A47 North Tuddenham to Easton Dualling

Scheme Number: TR010038

9.15 Alternative Wood Lane Junction Options Appraisal

ALTERNATIVE WOOD LANE JUNCTION OPTIONS APPRAISAL

Figure 2-3: Wood Lane Junction Alternative 42

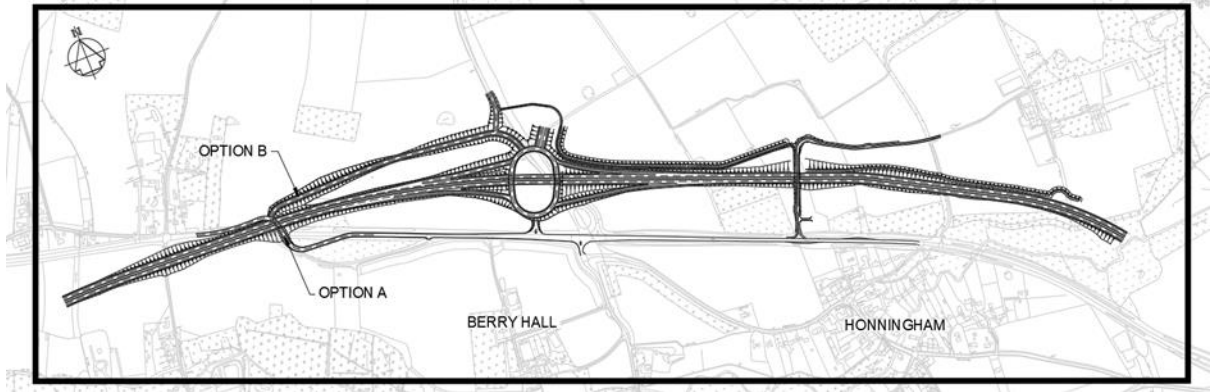
- 3.2.4 The mainline horizontal geometry shown is generally above the desirable minimum radius for a 120kph design speed and therefore complies with the required standards.
- 3.2.5 The exception to this is the 990m horizontal radius used at the eastern tie-in to the developed design. This falls one step below desirable minimum horizontal radius of 1,020m required of a 120kph design speed road and is therefore a horizontal relaxation.

- 3.2.6 As this relaxation occurs in advance of the junction diverge slip, widening to provide full stopping sight distance would be necessary to avoid this being classified as a “Departure from standard” (CD 109, Clause 2.13).
- 3.2.7 This has not been accounted for in the alternative design and would increase permanent land take accordingly.
- 3.2.8 The new mainline alignment would be closer to residential properties at Hall Farm, thus increasing likely noise impacts for properties already predicted to experience a significant adverse residual noise effect during operation of the Scheme design; see Environmental Statement Chapter 11 Noise and Vibration (**APP-150**).
- 3.2.9 Option A, with Lady’s Grove underpass, would also bring the proposed existing A47 side road closer to Hillcrest Cottage compared to the Scheme design.

- 3.2.24 An additional underpass is required in this option to maintain the existing A47. Such an underpass would require a headroom of 5.3m. Provision of this compliant headroom would require the proposed dualled A47 to be raised by approximately 5.3m.

- 3.2.25 The mainline would require to be raised above the Scheme design levels for a length of approximately 1,200m, with additional earthworks/materials and increased environmental impacts, especially landscape, visual and noise for properties around Church Lane, Sandy Lane and Park Lane, over this extent as a result. In particular, there is a risk to:

3.3.16 Indicative slip roads are shown to a similar length of the Scheme design, but do not take into account that the A47 mainline levels would require to be raised west of the junction to accommodate the proposed Lady's Grove underpass carrying the existing A47.

3.3.17 The eastbound diverge and westbound merge slips would not meet the UK DMRB requirements in their current form, due to the increased level difference to be overcome between the junction roundabout(s) and the mainline.

- 3.3.18 Based on the current slip road lengths a non-compliant vertical profile would be required to meet this level difference, resulting in critical departures from standard for both vertical geometry and stopping sight distance which would present safety issues within the conflict area of the junction.
- 3.3.19 Compliant slip roads would only be possible for this alternative layout by significantly increasing the length of the slip roads, resulting in increased land take and associated increase in environmental impacts.
- 3.3.20 The increased lengths in slip roads may require the alternative mainline A47 to move further south, which would impact the proposed Wood Lane Junction location with a similar shift to the south, resulting in operational difficulties with the proposed junction on the existing A47 south of Wood Lane junction.

Figure 2-4: Wood Lane Junction Alternative 2

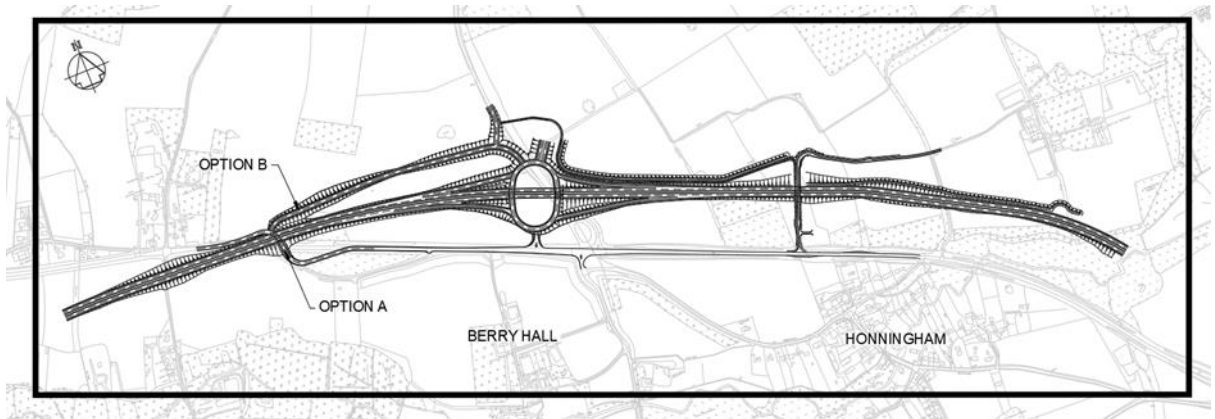
- 3.2.10 The mainline horizontal geometry shown falls below the desirable minimum radius for a 120kph design speed in two locations:
- A 720m horizontal radius is used east of the farm access underpass.

- A 720m horizontal radius is used at the eastern tie-in to the developed design.
- 3.2.11 Both these fall one step below desirable minimum horizontal radius of 1,020m required of a 120kph design speed road and are therefore horizontal relaxations.

- 3.2.12 As these relaxations occur in advance of the junction diverge slip, widening to provide full stopping sight distance would be necessary in order to avoid this being classified as a departure from the standard (CD 109, 2.13).

- 3.2.13 This has not been accounted for in the alternative design and would increase permanent land take accordingly.
- 3.2.14 Option A, with Lady’s Grove underpass, would also bring the proposed existing A47 side road closer to Hillcrest Cottage compared to the Scheme design.

- 3.2.2 The vertical design also needs to provide clearance for two junction underbridges that replace the single structure of the Scheme design.
- 3.2.3 An additional underpass is required in this option to maintain the existing A47. Such an underpass would require a headroom of 5.3m. Provision of this compliant headroom would require the proposed dualled A47 to be raised by approximately 5.6m.

- 3.2.4 The mainline would require to be raised above the Scheme design levels for a length of approximately 1,200m, with additional earthworks/materials and increased environmental impacts, especially landscape, visual and noise for properties around Church Lane, Sandy Lane and Park Lane, over this extent as a result. In particular, there is a risk to: the Scheme design's 'no significant effects' assessment for Noise Important Area 5201 in Environmental Statement Chapter 11 Noise and Vibration (**APP-050**); and the effectiveness of the proposed noise barrier 3 mitigation north of Church Lane could be compromised as mitigation for properties at risk of significant noise impacts from the Scheme design. These features are shown on Sheet 2 of Environmental Statement Figure 11.2 (**APP-074**).

- 3.3.22 Indicative slip roads are shown to a similar length of the Scheme design, but do not take into account that the A47 mainline levels would require to be raised west of the junction to accommodate the proposed Lady's Grove underpass carrying the existing A47.

- 3.3.23 The eastbound diverge and westbound merge slips would not meet the DMRB requirements in their current form, due to the increased level difference to be overcome between the junction roundabout(s) and the mainline.

- 3.3.24 Based on the current slip road lengths a non-compliant vertical profile would be required to meet this level difference, resulting in critical departures from standard for both vertical geometry and stopping sight distance which would present safety issues within the conflict area of the junction.

- 3.3.25 Compliant slip roads would only be possible for this alternative layout by significantly increasing the length of the slip roads, resulting in increased land take and associated increase in environmental impacts.
